Application No: EP/124/20/HH
Site Address: Little Dormers 23 Upper Drive East Preston BN16 1QN
Description of works: New bay and porch skirt roof to the front elevation, and roof linked detached double garage.

Thank you for your internet representation made on 27th November 2020 which has been recorded as an objection with the comments as follows:

This council's Planning & Licensing Committee considered this Application at its meeting on Monday, 23rd November. The applicants attended and addressed the meeting.

Garage Plans and Elevations -
Proposed

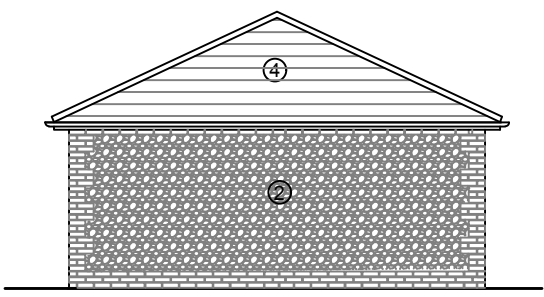
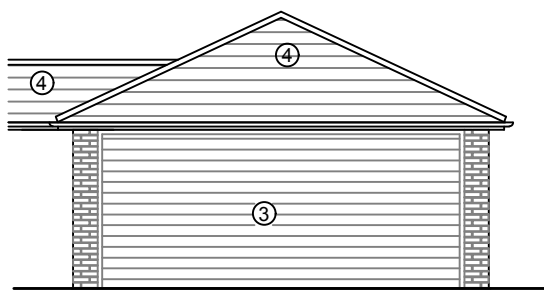
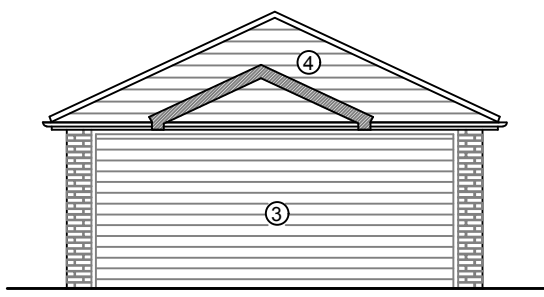
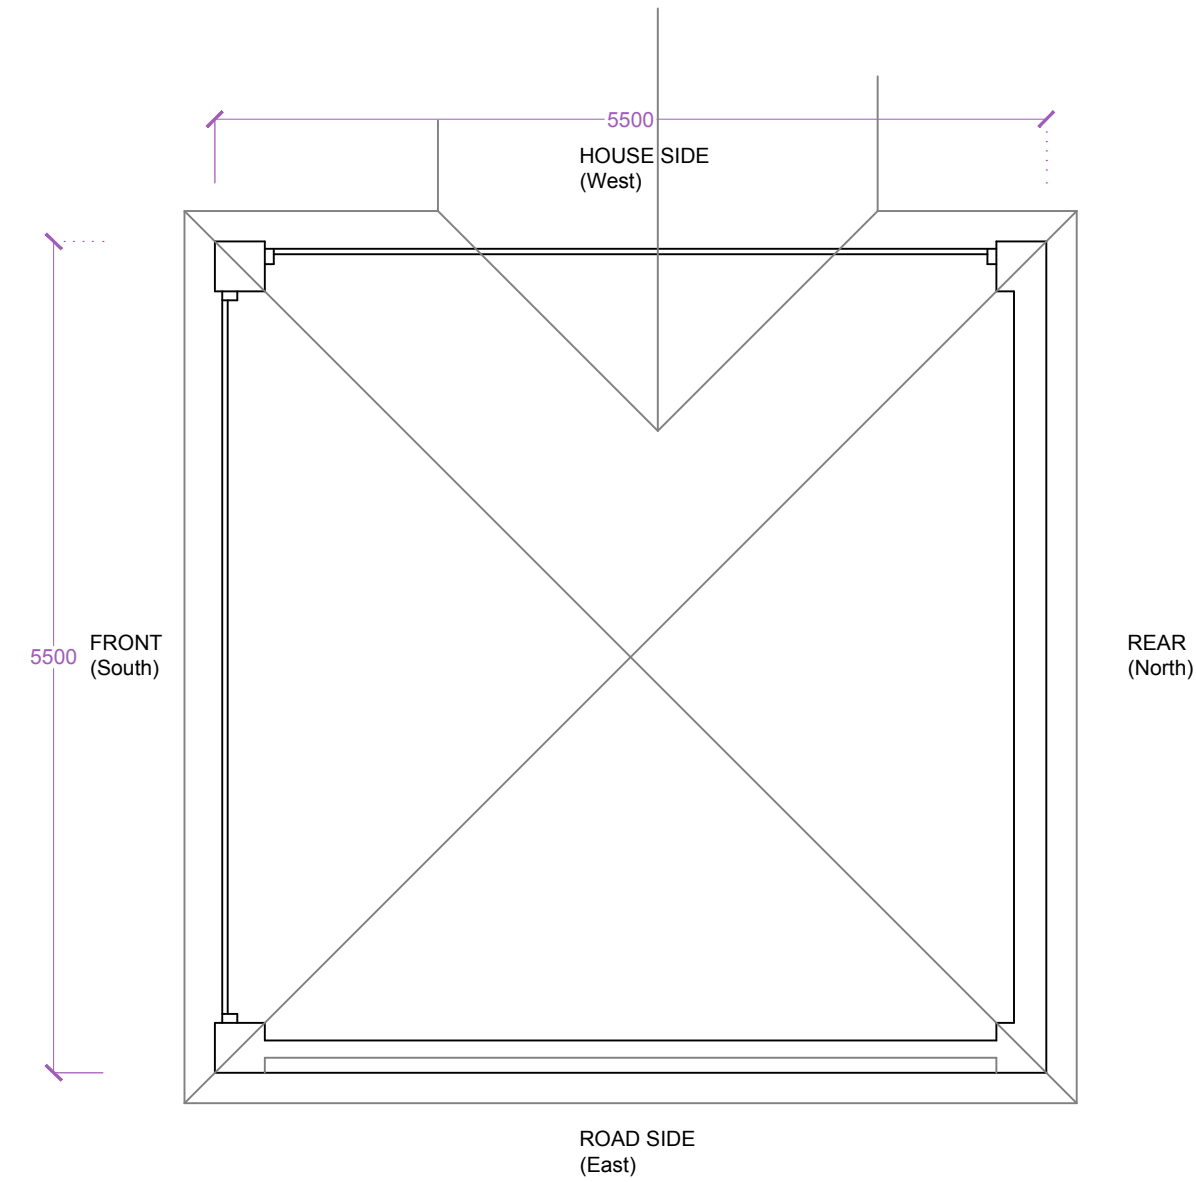
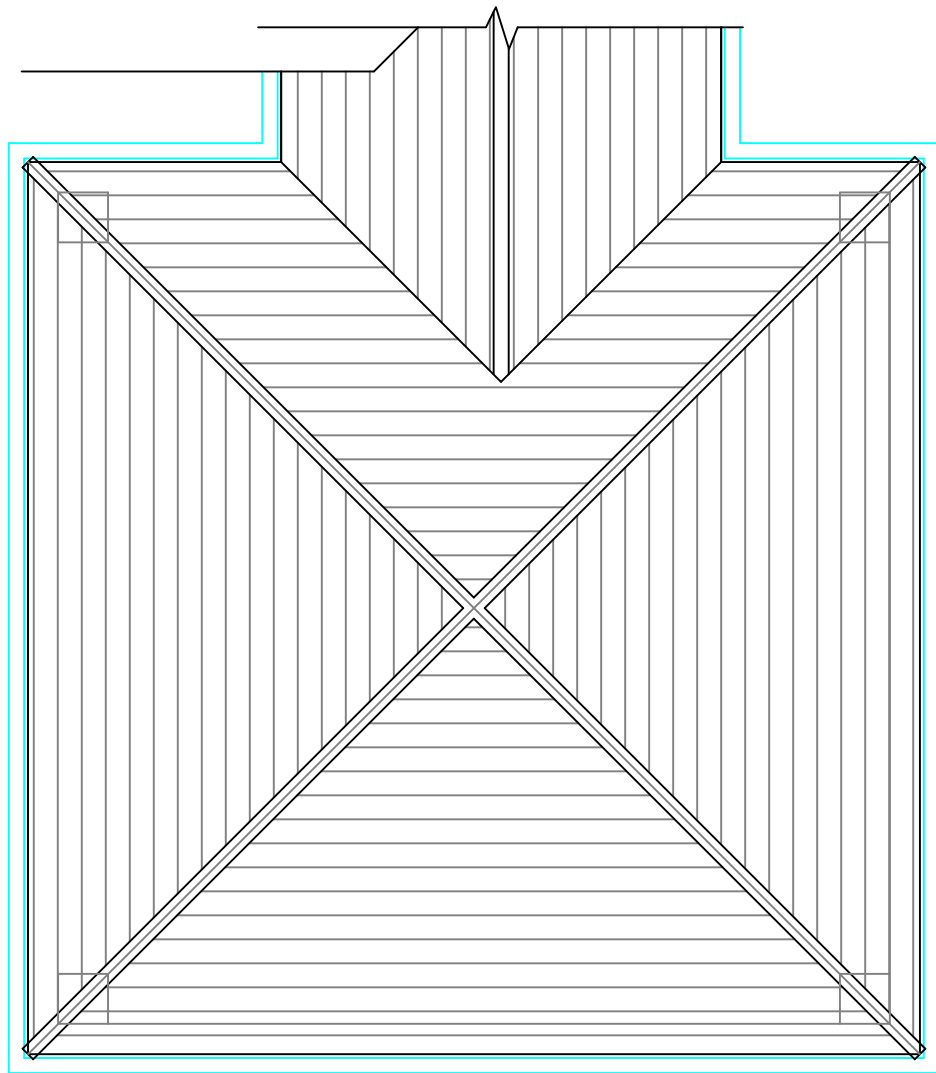
The committee felt the proposal was an unacceptable change to the streetscene, and the mass and size of the proposed garage was unneighbourly.
